Jeanie Bourke - FW: The Inn at Diamond Cove - permit review

From: Barry Yudaken [mailto:yudaken@archetypepa.com]
Sent: Monday, April 15, 2013 12:06 PM
To: David Lloyd; Susan Geffers
Subject: The Inn at Diamond Cove - permit review

CBL: 083E E4600 **Permit ID:** 2013-00436

4/10/2013-JMB/Building:

A1.00

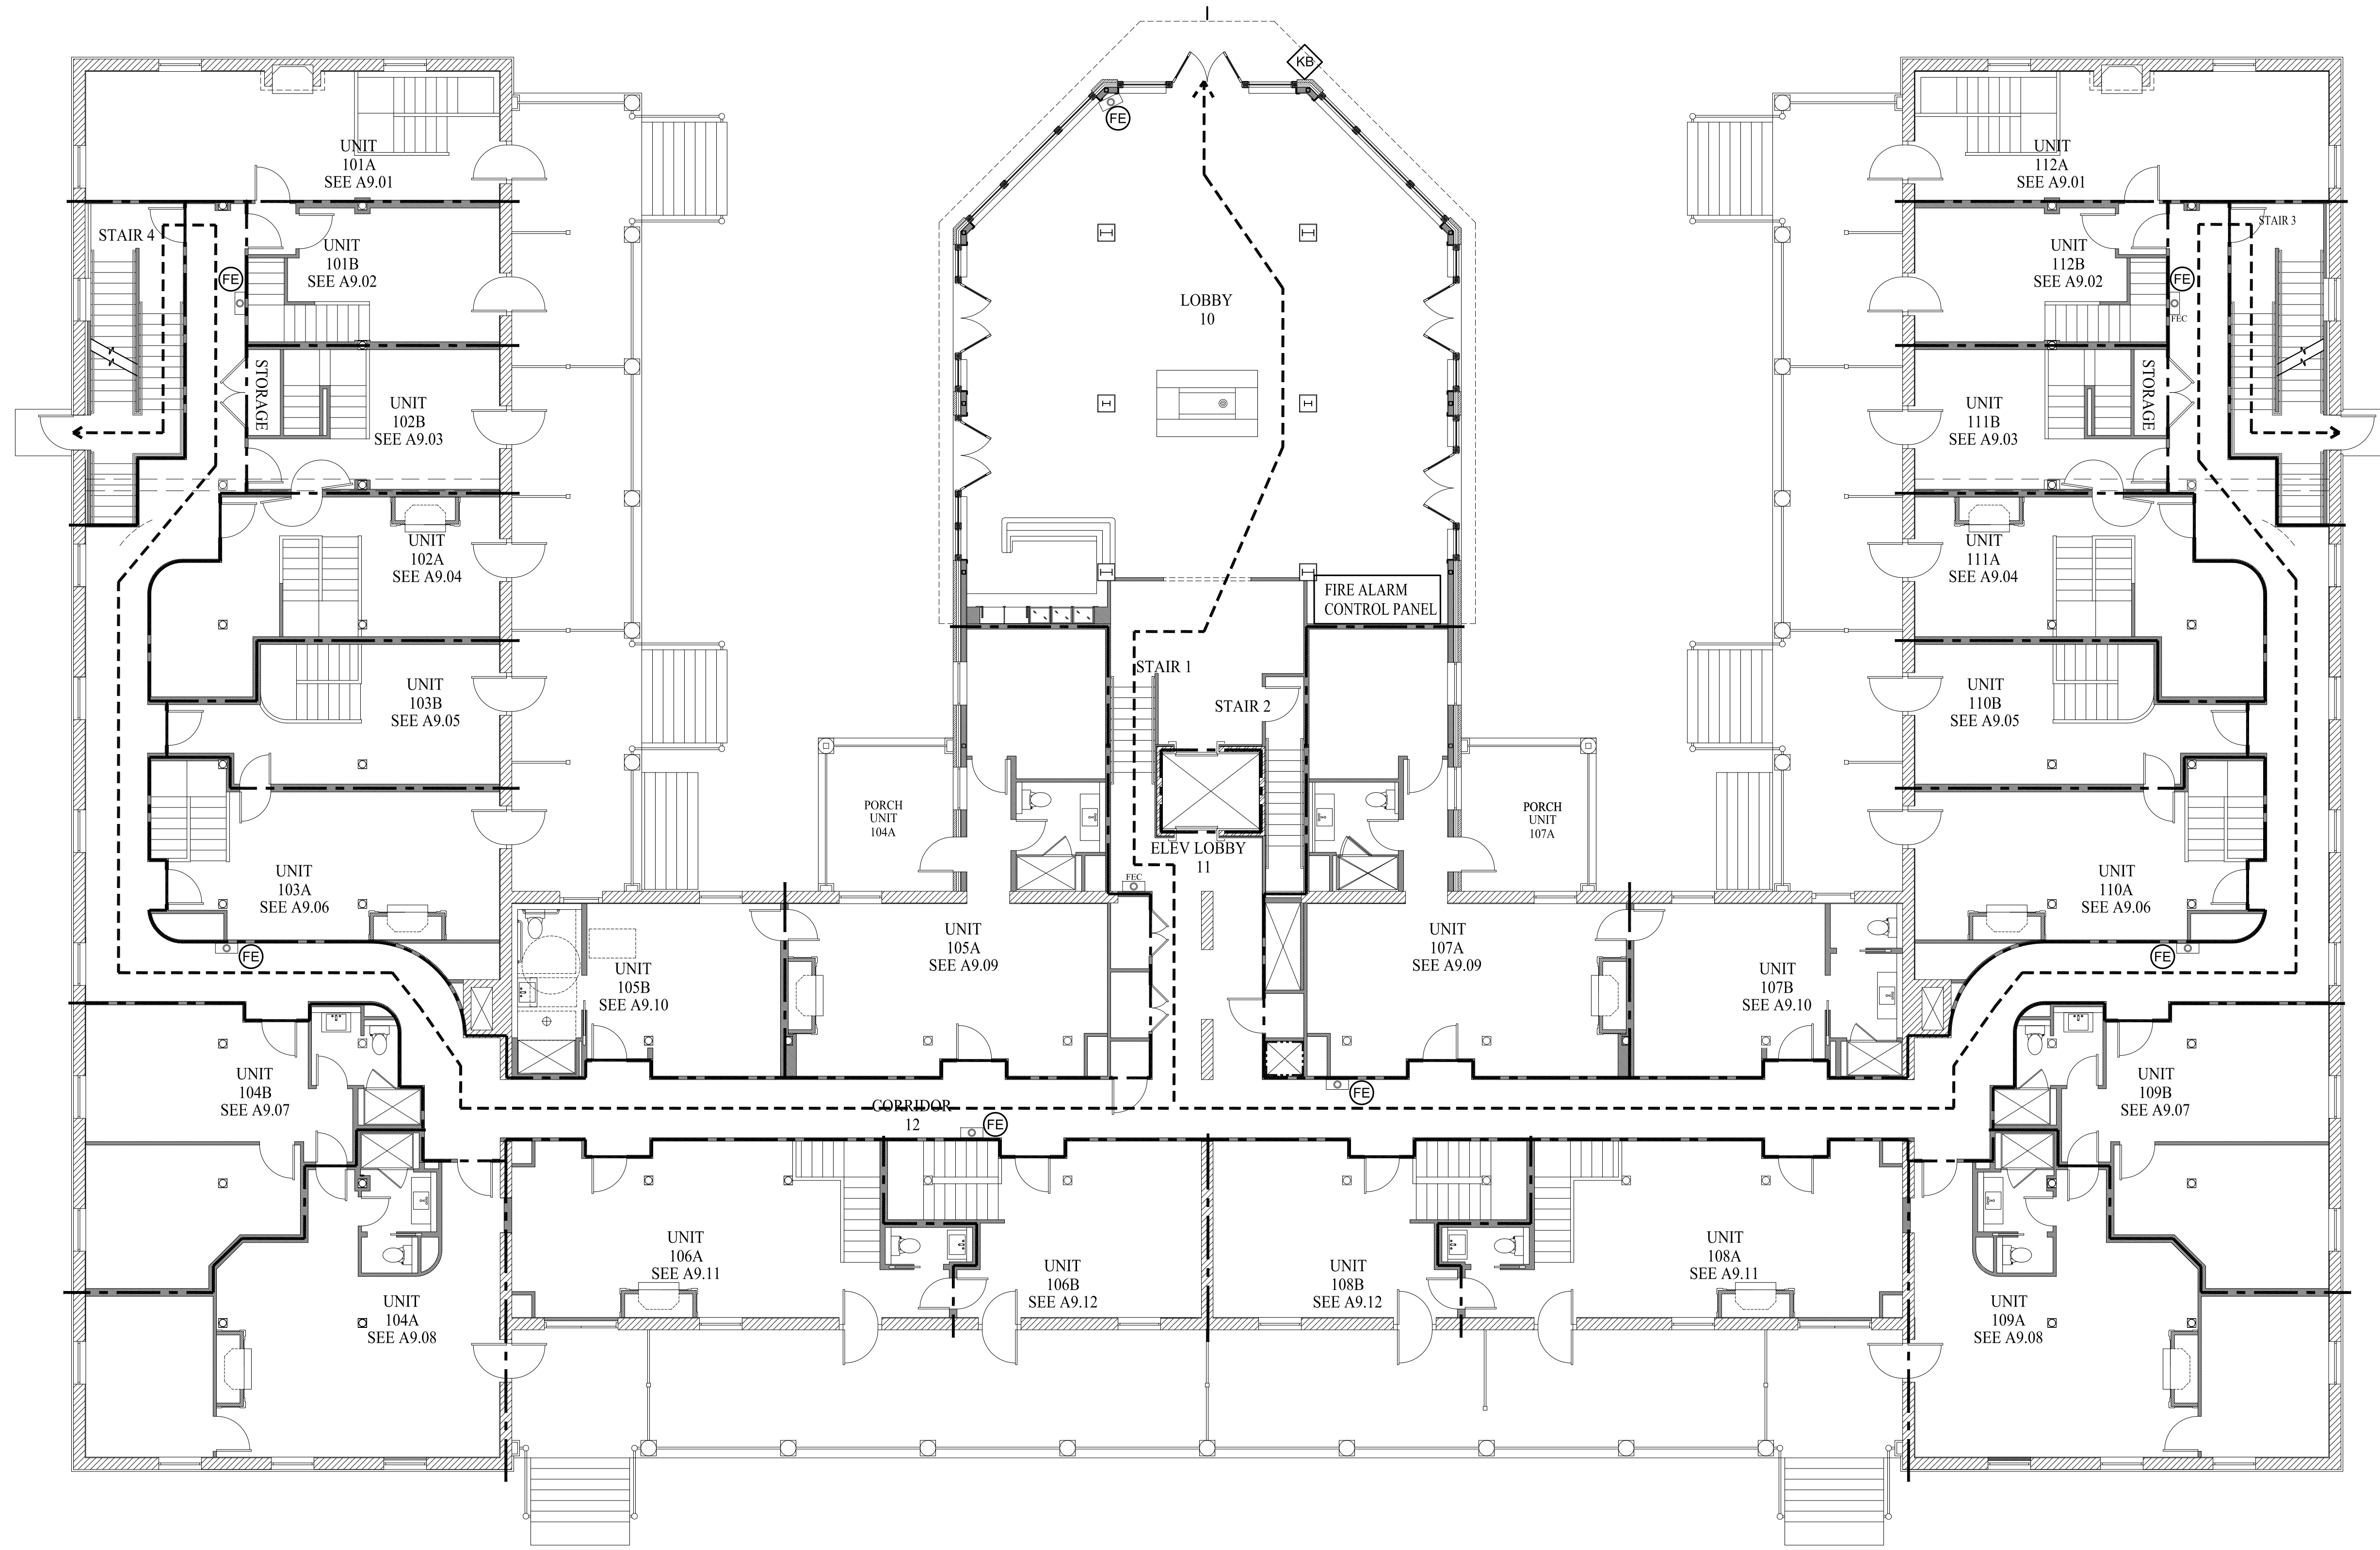
8. Plan A.100 - It appears the entry doors at Units 111A & 102A impede on 1/2 the egress width for Units 111B & 102B per Sec. 1005.2 **We will change all these and have doors swing in – See revised plan A1.00.**

10. Plan A1.00 - Basement units 101, 102, 111, 112 entry doors and partition walls are within a 1 hour rated exit enclosure, not a corridor. Justify the assigned wall types and door rating **agree we will show as one hour – see revised plan drawing A1.00**

A0.02

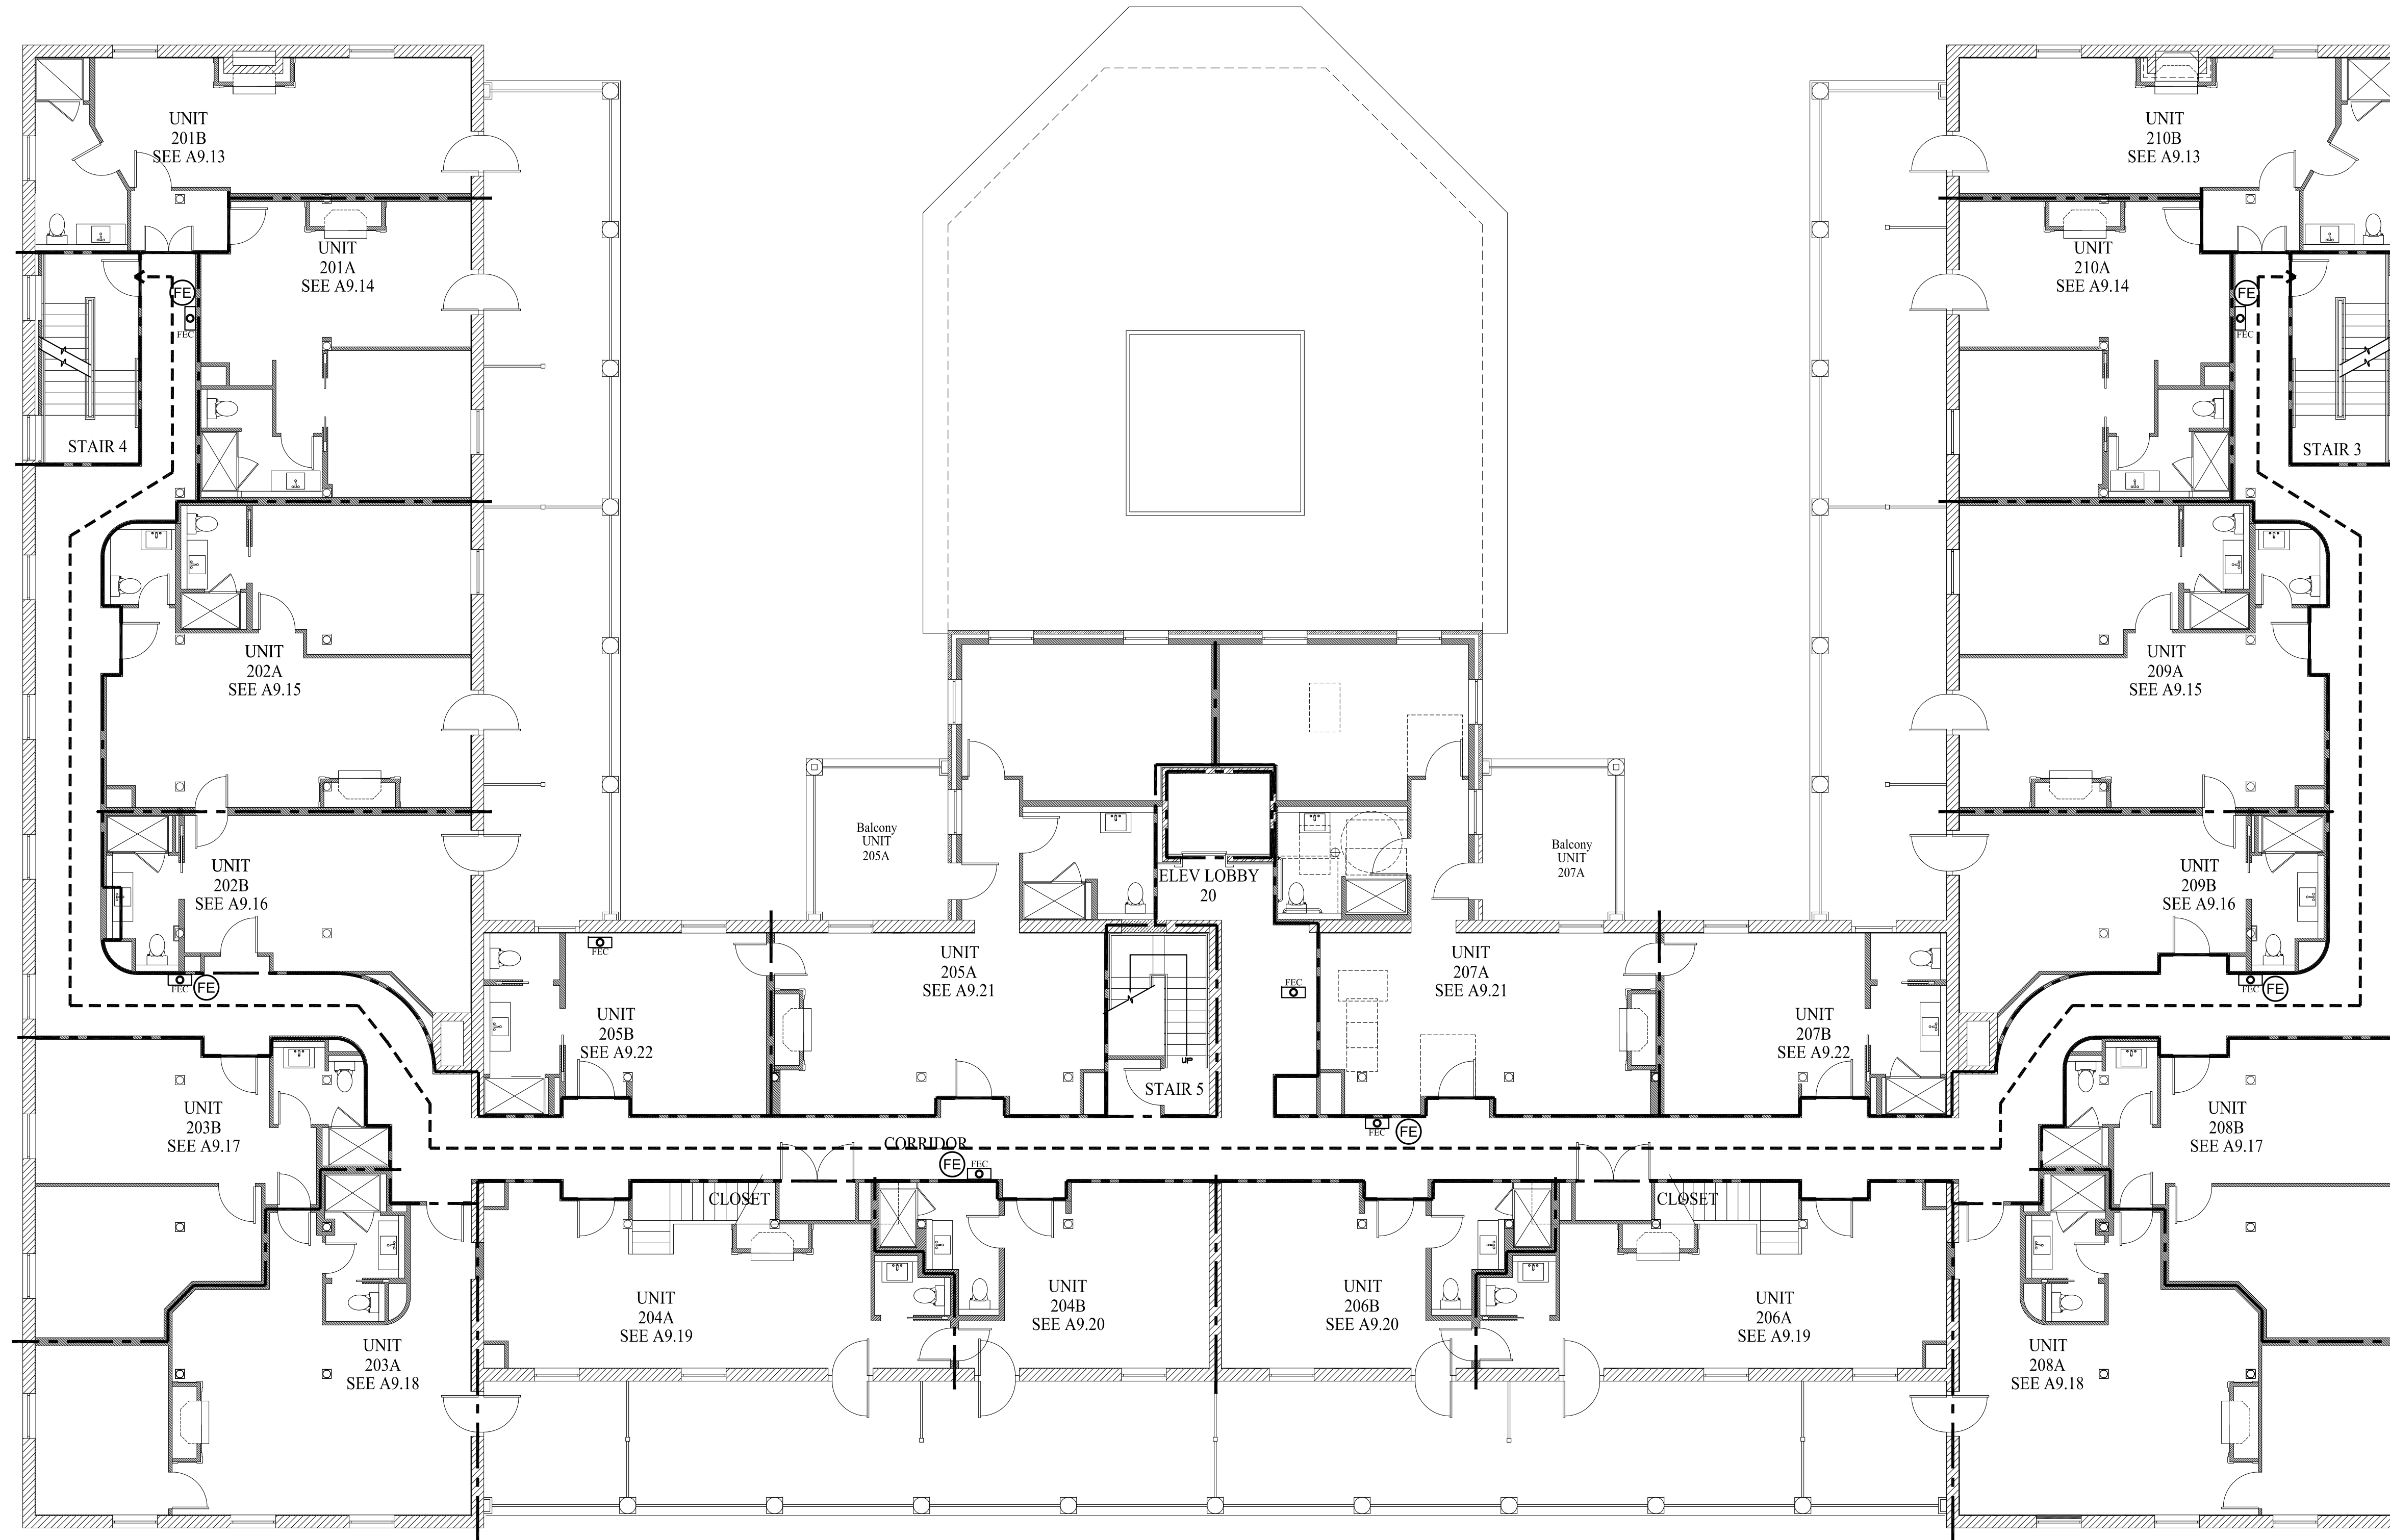
4. Plan A0.02 - verify the X'd out (shaft or opening) near unit 107A and above the kitchen exhaust shaft it is wall type **W5 shown on A1.01 and A1.02, Also I picked up that it was incorrectly labeled on A1.03 so we have adjusted to W5 – see revised A1.03.**
